**KIRKLEES METROPOLITAN COUNCIL
INVESTMENT & REGENERATION SERVICE**

**DELEGATED DECISION TO DETERMINE APPLICATIONS FOR
NON-MATERIAL AMENDMENTS**

Reference No: **2023/NM/90937/E**

Site Address: 22, Station Road, Batley, WF17 5SU

DRAWING TITLE:
Internal Finishes Basement/Ground
 PROJECT DESCRIPTION:
Conversion of existing into Apts
 PROJECT ADDRESS:
22 Station Rd, Batley, WF17 5SU

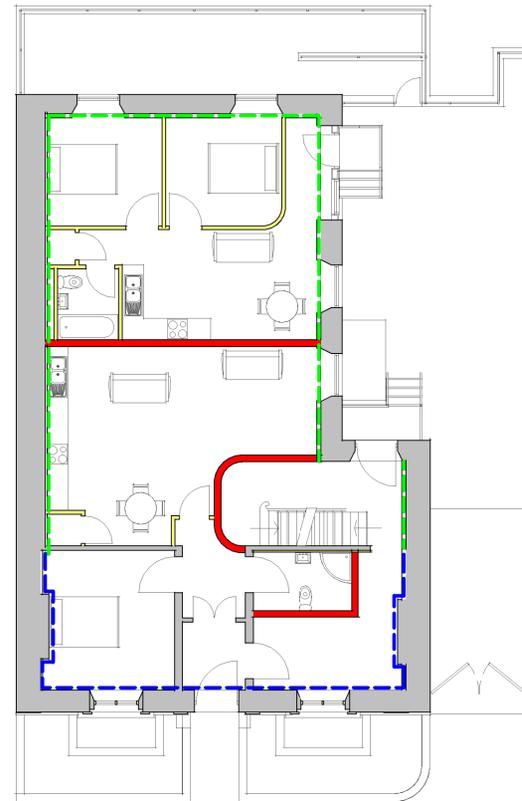
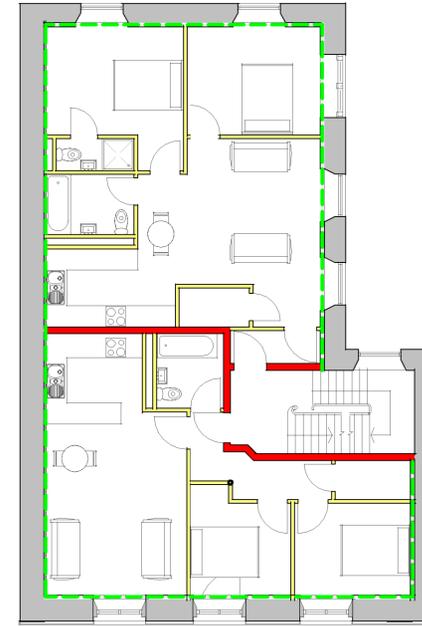
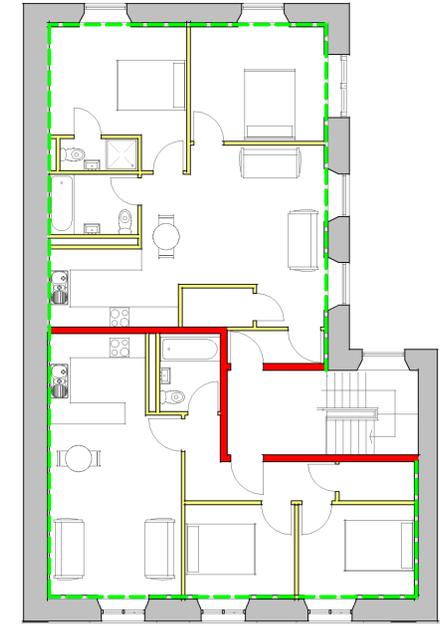
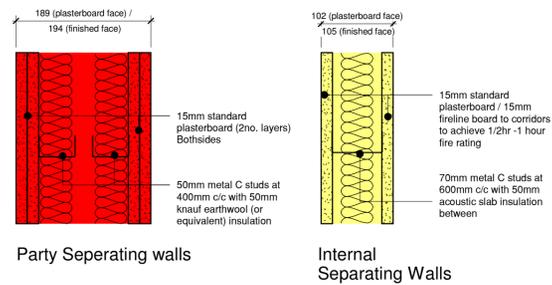
The submitted plans and application form indicate that the non-material amendment being sought is to alter the stairs and access to the side, alter the partition wall on the ground floor and alterations to the windows on the front elevation at basement level.

To conclude, the amendment shown on drawings “Internal Finishes Basement/Ground – 21057-8006”, “Proposed Basement/Ground Floor Plan – 21057-8003”, “Proposed 1st & 2nd Floor Plan – 1057-8004” and “Proposed Elevations – 21057-8001” are considered appropriate to be regarded as a non-material amendment to the previous planning approval 2019/93755.

DRAWING TITLE:
Proposed First and Second Floor
 PROJECT DESCRIPTION:
Conversion of existing into Apts
 PROJECT ADDRESS:
22 Station Rd, Batley, WF17 5SU

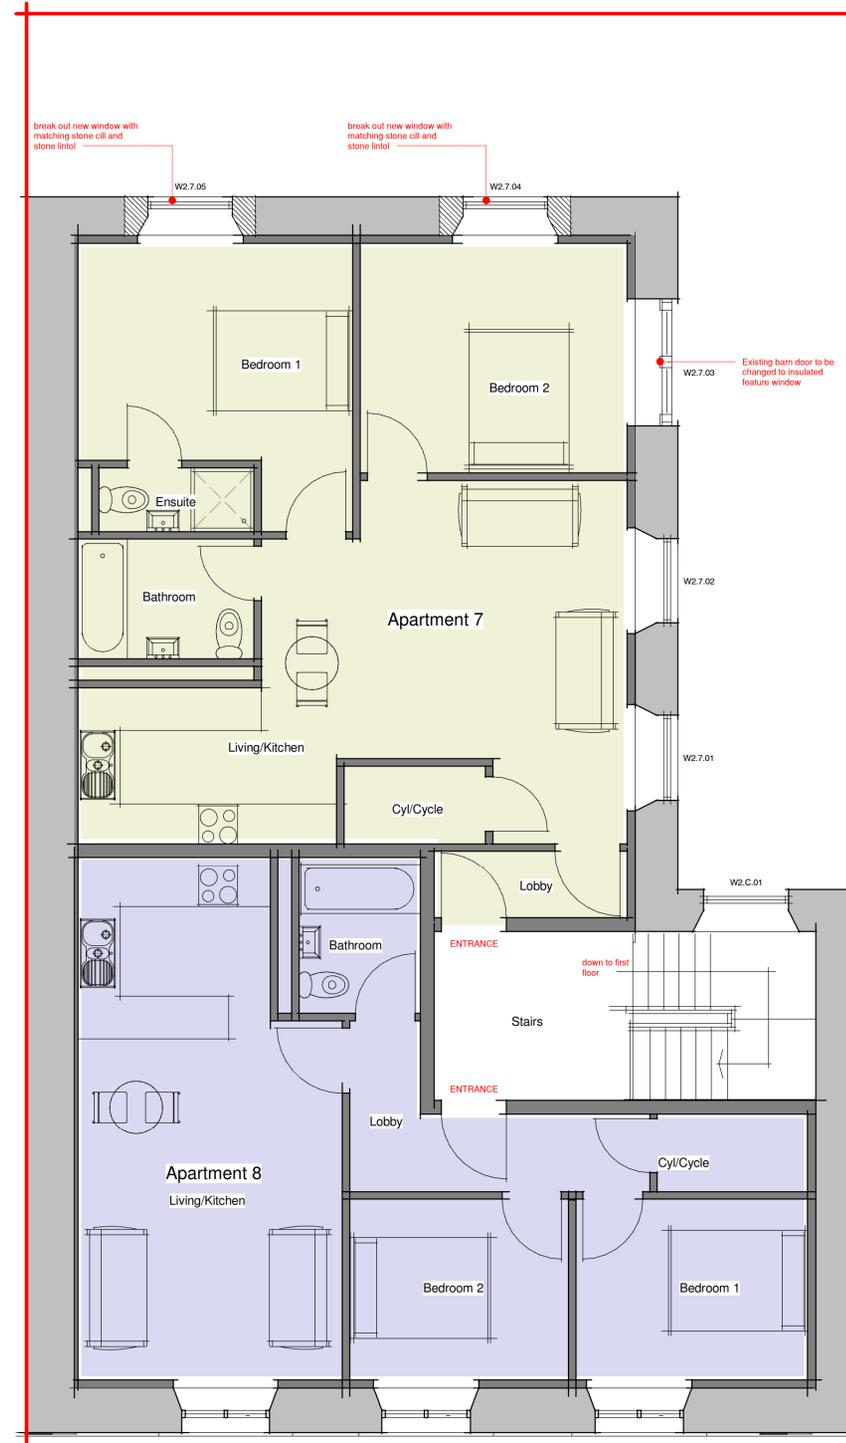
- Internal Finishes Basement/Ground – 21057-8006
- Proposed Basement/Ground Floor Plan – 21057-8003
- Proposed 1st & 2nd Floor Plan – 1057-8004
- Proposed Elevations – 21057-8001

DRAWING TITLE:
Proposed Basement/Ground Floor Plan
 PROJECT DESCRIPTION:
Conversion of existing into Apts
 PROJECT ADDRESS:
22 Station Rd, Batley, WF17 5SU

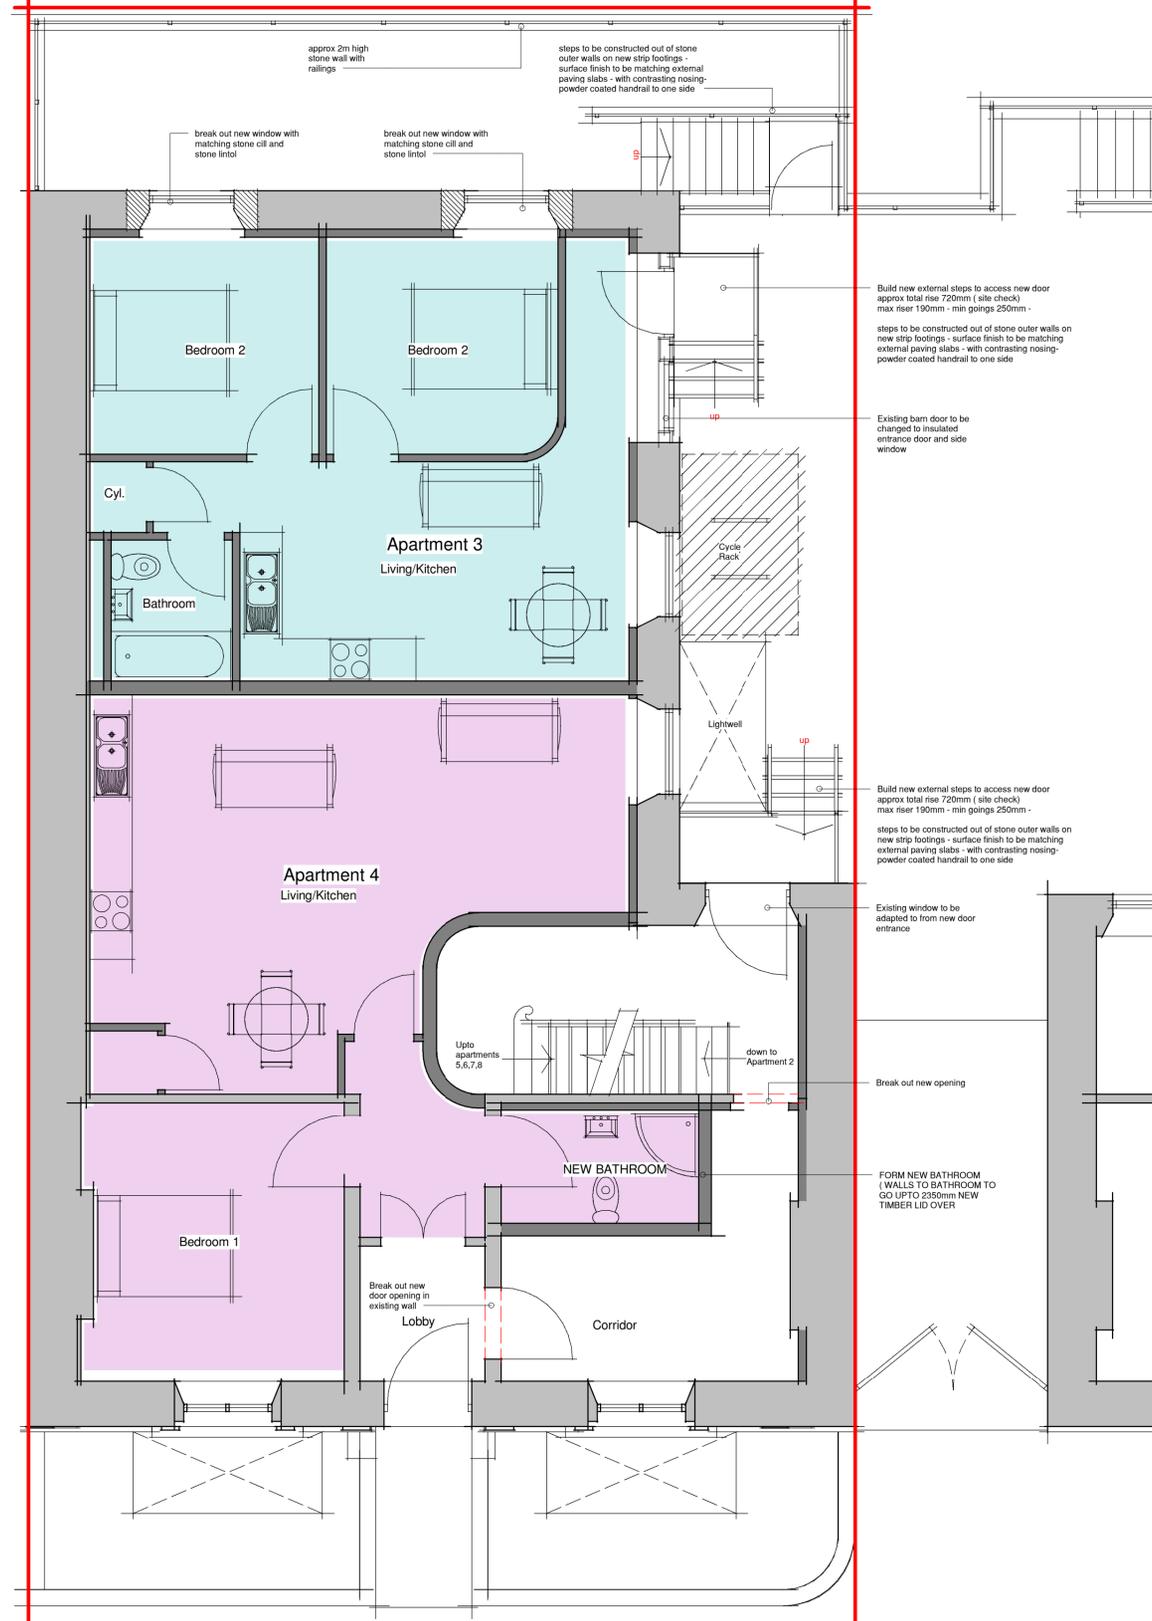
The proposed internal reconfiguration would reduce the internal floor area of Apartment 4, removing a bedroom from the apartment and creating a corridor. The apartment would exceed the minimum recommended floor area as outlined in the Nationally Described Space Standards and would therefore not cause any significant harm to the amenity of the future occupiers. The amendments to the front elevation openings at basement level would enlarge the openings in comparison to the original approval thus improving the proposal in terms of living conditions for the future occupiers.

DRAWING TITLE:
Proposed Elevations
 PROJECT DESCRIPTION:
Conversion of existing into Apts
 PROJECT ADDRESS:
22 Station Rd, Batley, WF17 5SU

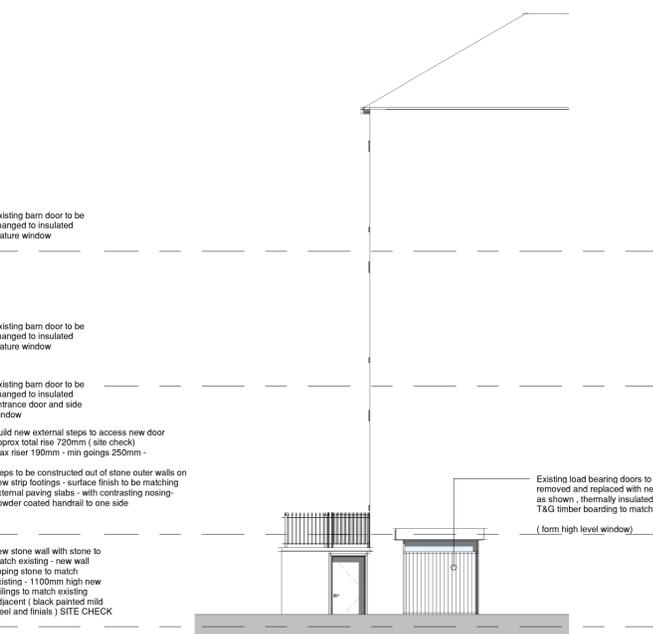
The proposed amendments would alter the opening and access to the rear of the property, enlarge the openings at basement level and would include interior alterations. The proposed amendments would not change the scale of the original approval and would therefore be inconsequential.

The proposed development would alter the access steps to the side of the property, this would be a minor alteration to the exterior of the property. The impact on the historic character of the building has been assessed in detail under 2023/90925 and considered acceptable. The proposal would result in no additional harm to residential amenity over and above the approved scheme. The proposed amendments to the openings on the front elevation would be at basement level and would not be visible from street level. Therefore, they would not cause any harm to the visual appearance of the approved development.
